DECISION DELEGATED TO HEAD OF PLANNING

Application No: H09-1285-25 **Applicant:** Mr & Mrs Ringer

Proposal: Extension to existing garage to provide a ground floor games room & first floor ancillary accommodation incidental to the main dwelling

Location: 18 Fishpond Lane Holbeach Spalding

ELEVATIONS - SHEET 2
Proposed Extension

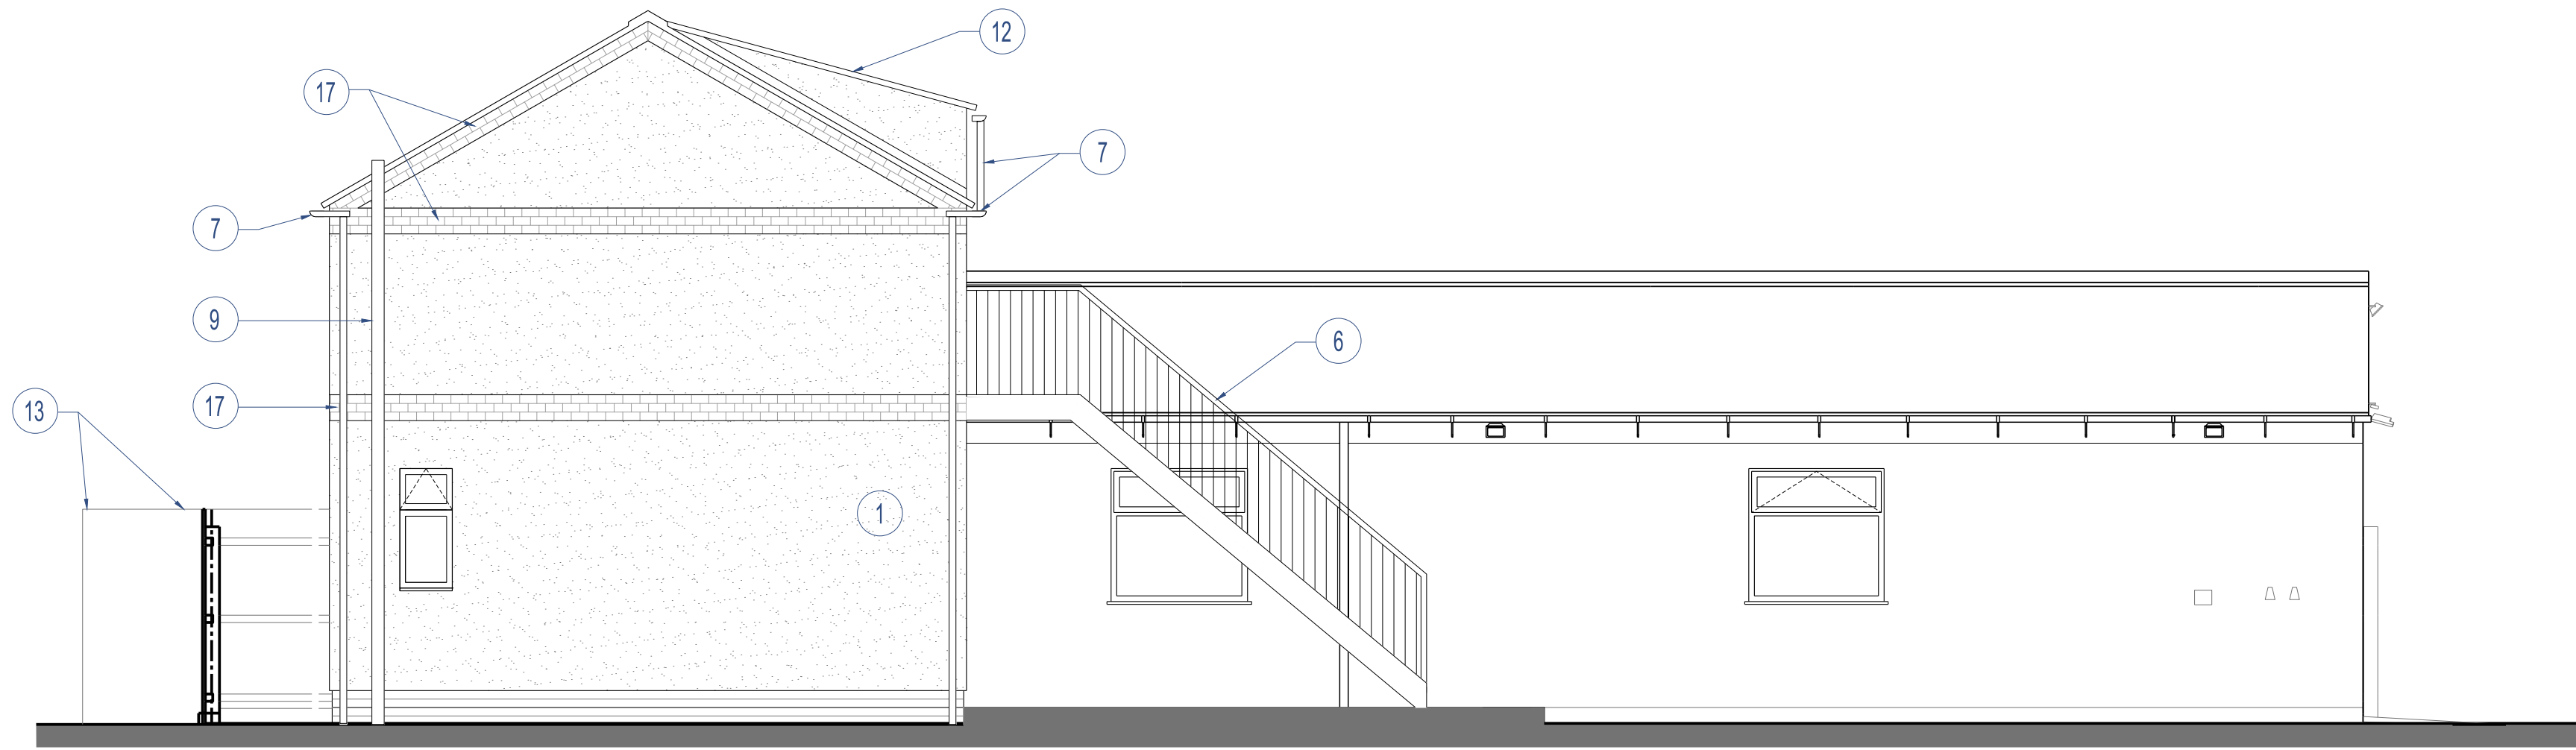
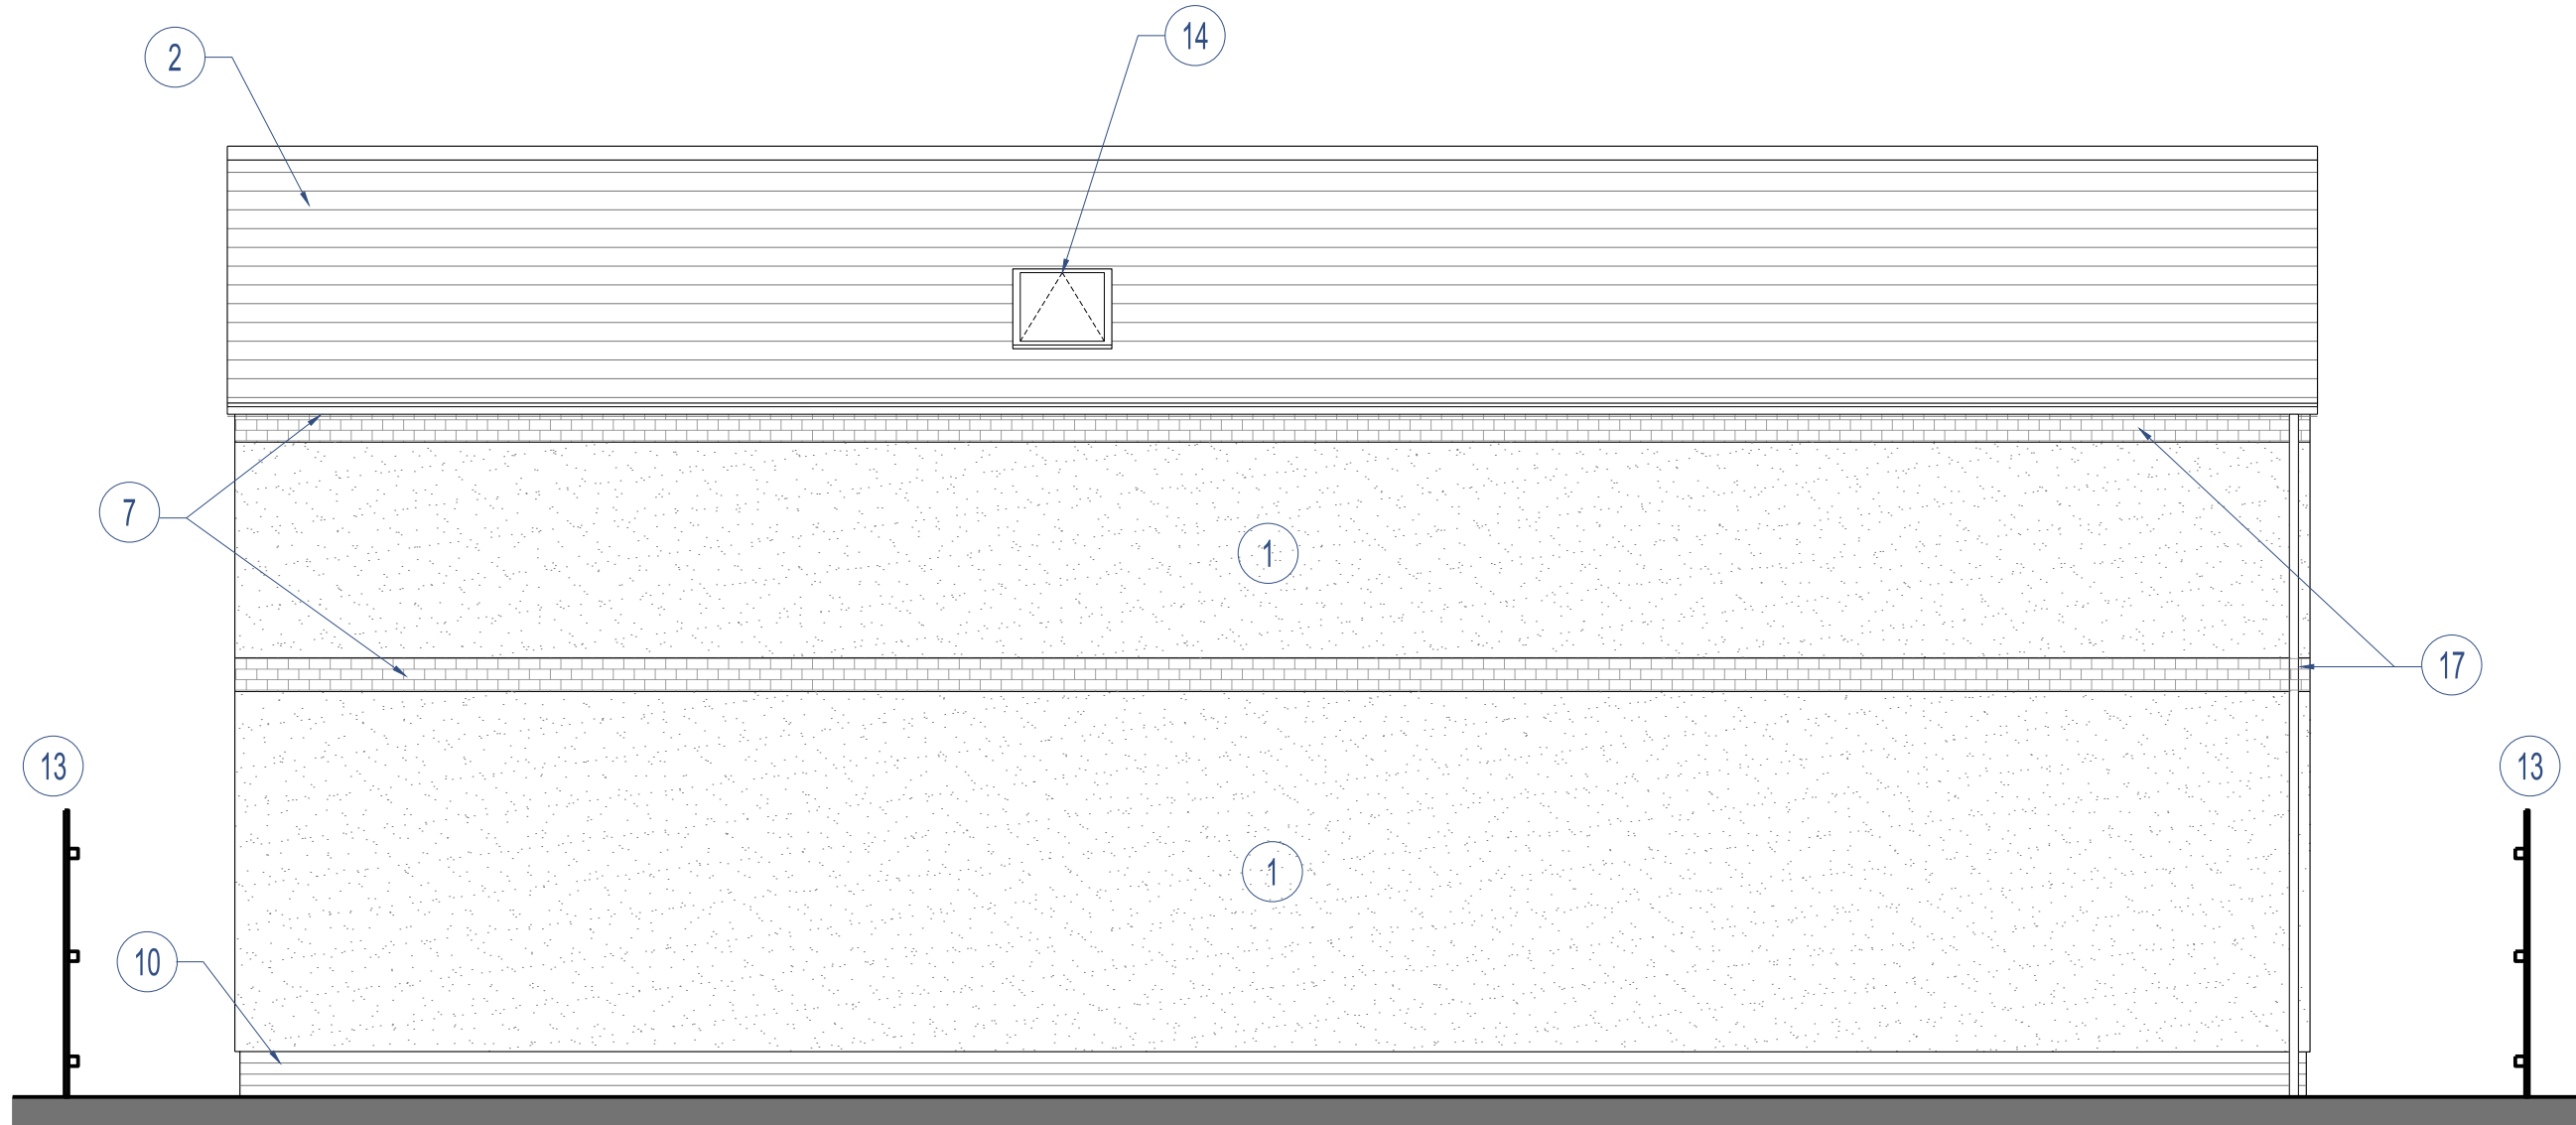
This is a householder application for an extension to a garage to form a ground floor games room and first floor accommodation at 18 Fishpond Lane. The extension would project from the south-eastern elevation of the garage, forming an "L" shape. The extension would have a length of 9.8m, measured from the ground floor, or 13.83m measured from the first floor. It would have a depth of 5.65m. To the eaves, it would measure 4.63m, rising to 6.34m at the apex. The building would be rendered white, with metal windows and stairs.

As outlined above, when taken as a whole, the extensions would result in a building of comparable scale to the host dwelling. The heights are comparable, albeit the eaves of the outbuilding would be far larger than that of the host, and the floor space is approximately 70% of the host. This would prevent the building from being functionally or visually subservient to the host. The resultant building fails to provide an adequate relationship to the host, resulting in the two being visual distinct and reading as separate structures. The significant height would also result in the building being visible from the roadside, breaking the established built form of the area. The significant height would also increase visibility from neighbouring dwellings, harming the character of these properties.

The extension would also result in increased overshadowing, particularly of number 20's garden. Whilst the location to the far of the rear garden would reduce the impact somewhat, as no habitable space would be impacted, it would still be detrimental to the overall enjoyment of the garden space.

**TITLE:**  
FLOOR PLANS  
General Arrangement

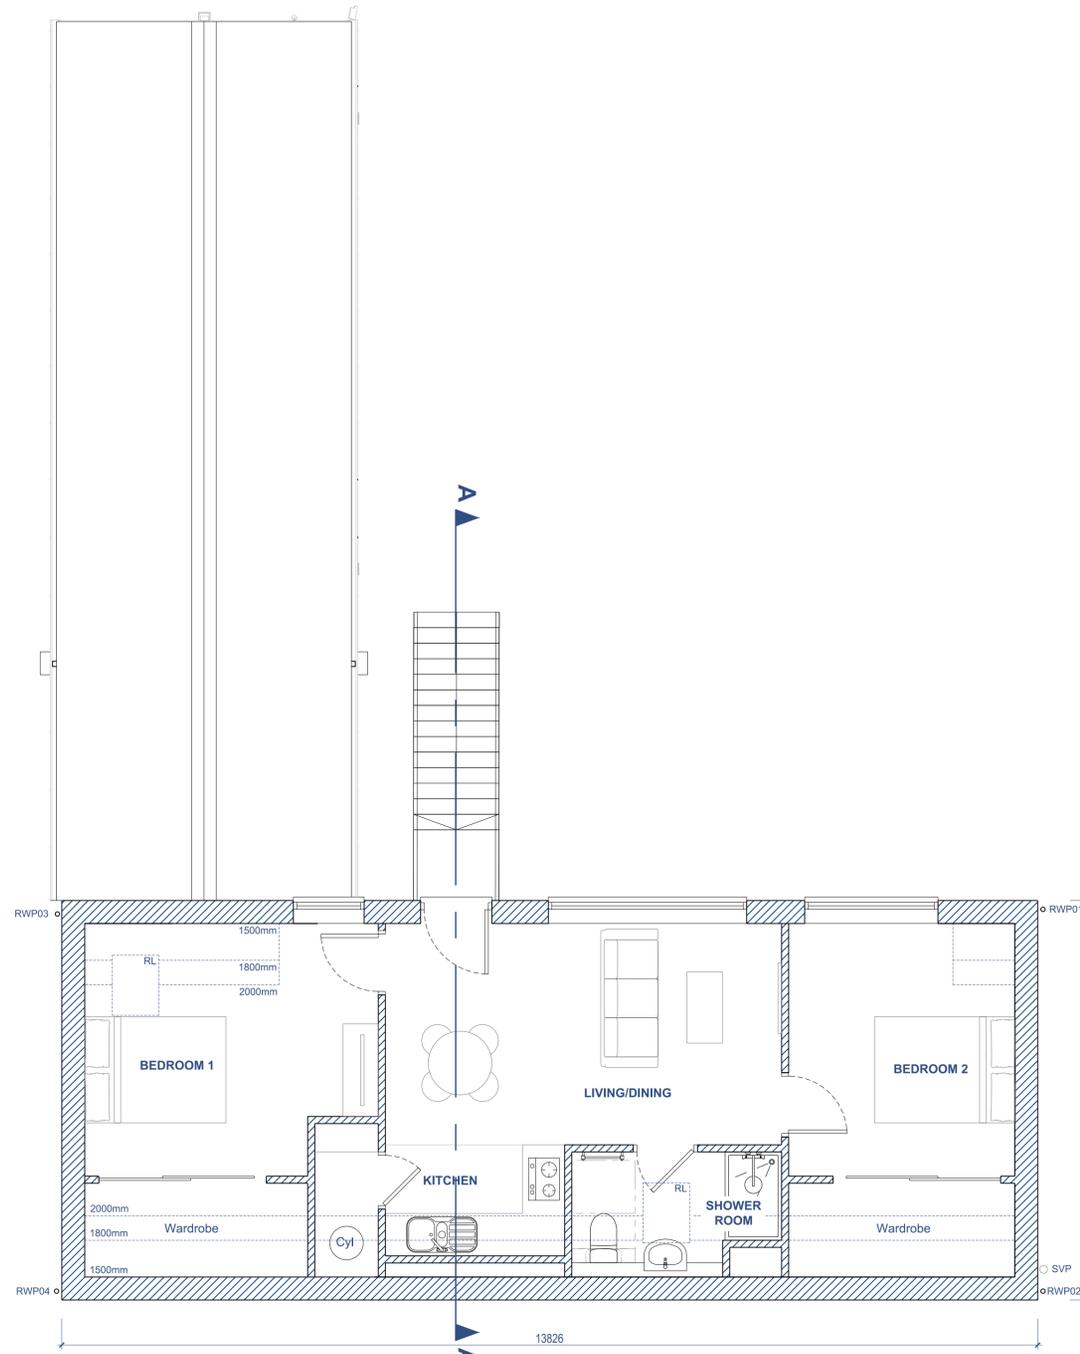
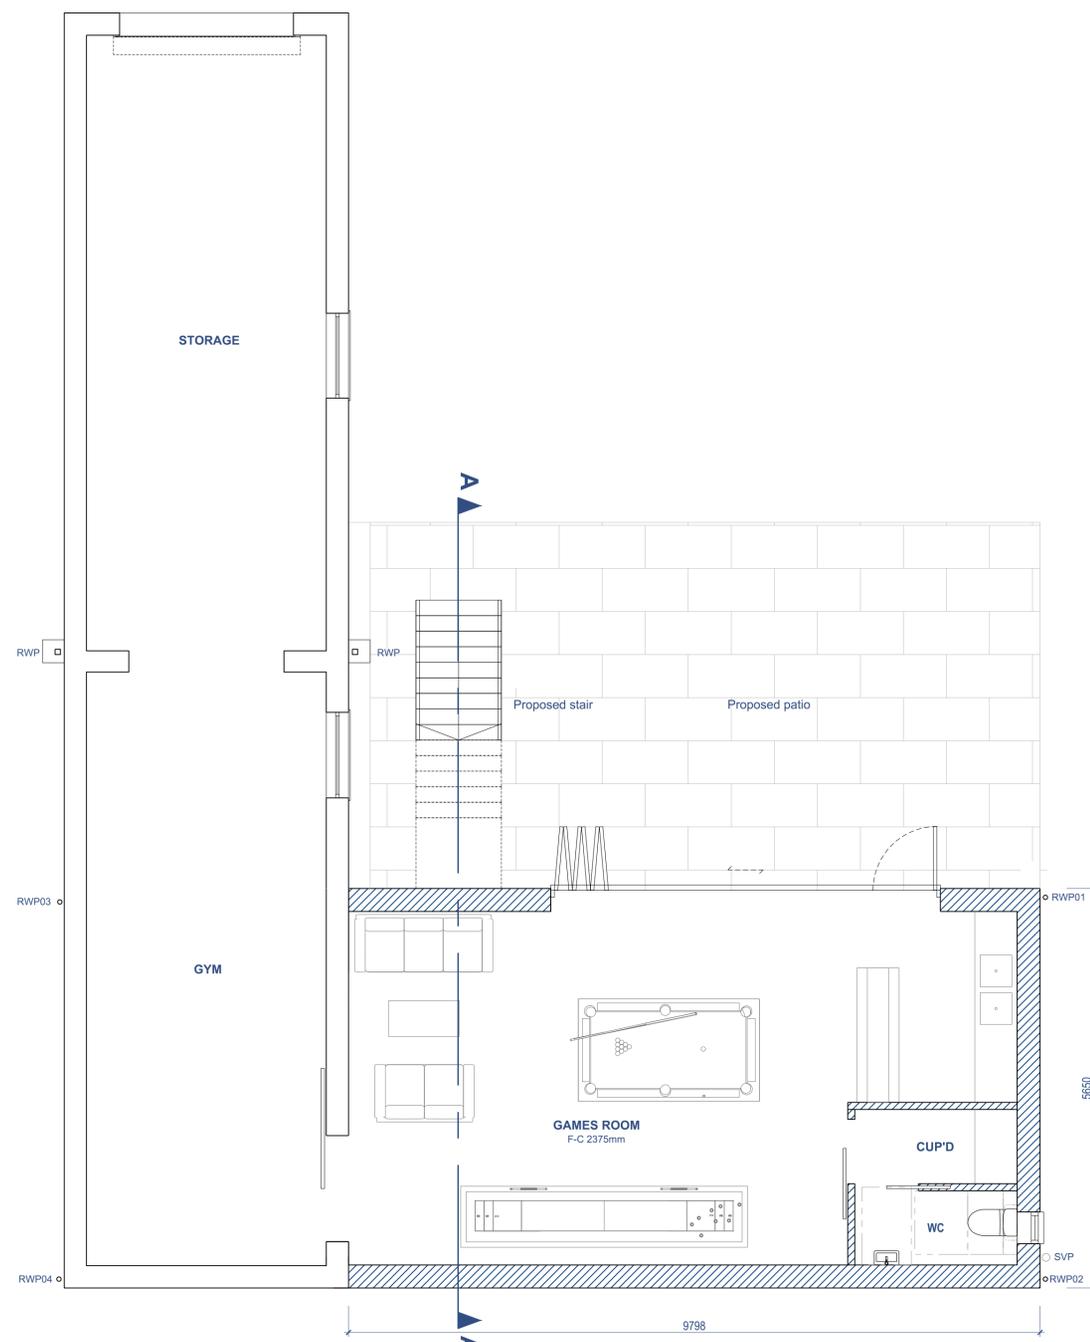
The submitted plans illustrate an internal layout comprising a games room, gym and storage to the ground floor, with two bedrooms, a bathroom, living/dining room and kitchen to the first floor.

The building proposed, would be of a comparable height to the existing dwelling. The total floor area would of the outbuilding following the extensions would be approximately 70% of the host dwelling's. Taken in isolation of the wider extensions, the first floor aspect would still have a floor area of 65sqm, providing two bedrooms, a living room and bathroom. These would, in effect, enable entirely independent living from the host dwelling.

The positioning of the proposed windows would mean that views are primarily of 18 Fishpond Lane's garden. That being said, some views of the garden of number 20 would be obtainable from bedroom 2, resulting in some level of amenity harm.
